December 19, 2023

**RE: Bank of Oklahoma – 6301 Jefferson
Grading and Drainage Plans
Engineer's Stamp Date: 12/14/23
Hydrology File: E17D016C**

Re: *Bank of Oklahoma – 6301 Jefferson
Grading and Drainage Plans
Comment Responses to December 6, 2023 comments*

# C500

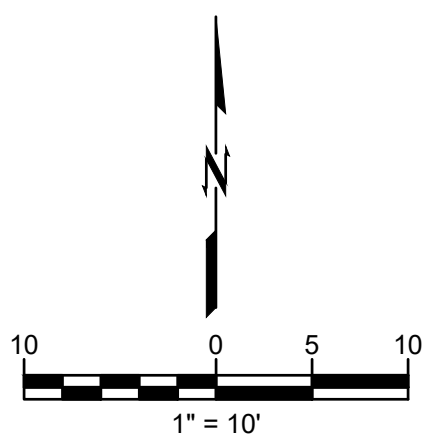
1. Per the DPM, the following must be on the Grading Plan. Please note the Grading Plan must be a stand-alone construction document.
 - a. Please provide a Vicinity Map. Typically, this is the Zone Atlas. This can be downloaded in pdf format from the City of Albuquerque's website.

- b. Please provide the Benchmark information (location, description and elevation) for the survey contour information provided.
 - c. Please provide the FIRM Map and flood plain note with effective date.

2. Please place all the topographic information that CSI provided on the overall Grading & Drainage Plan. Then the second sheet can be the closeup view of the proposed building. (C500) Please show the existing finish floor of the building to be 5144.6' on the plans. These are the only two that Hydrology needs to approve.

6. Please add a note which states, "The Owner has elected to pay the Payment in Lieu for the required Stormwater Quality Volume. The Payment in Lieu Amount = $\text{XXX CF} \times \$8/\text{CF} = \XXX.00 ".

- d. Please provide a legal Description of the property.
 - ***Response: A zone atlas map has been provided in the upper right corner of both sheets. The benchmark information is provided in the upper corner of the sheets. A floodplain note has been added on the Grading and Drainage Plans. A legal description has also been listed.***

- ***Response: Acknowledged. New Grading and Drainage plans have been created that have an overall and zoomed in view. The FFE above has been listed on the existing building in both sheets.***

- ***Response: Acknowledged. This note is added on the Overall Grading & Drainage Plan (C500).***
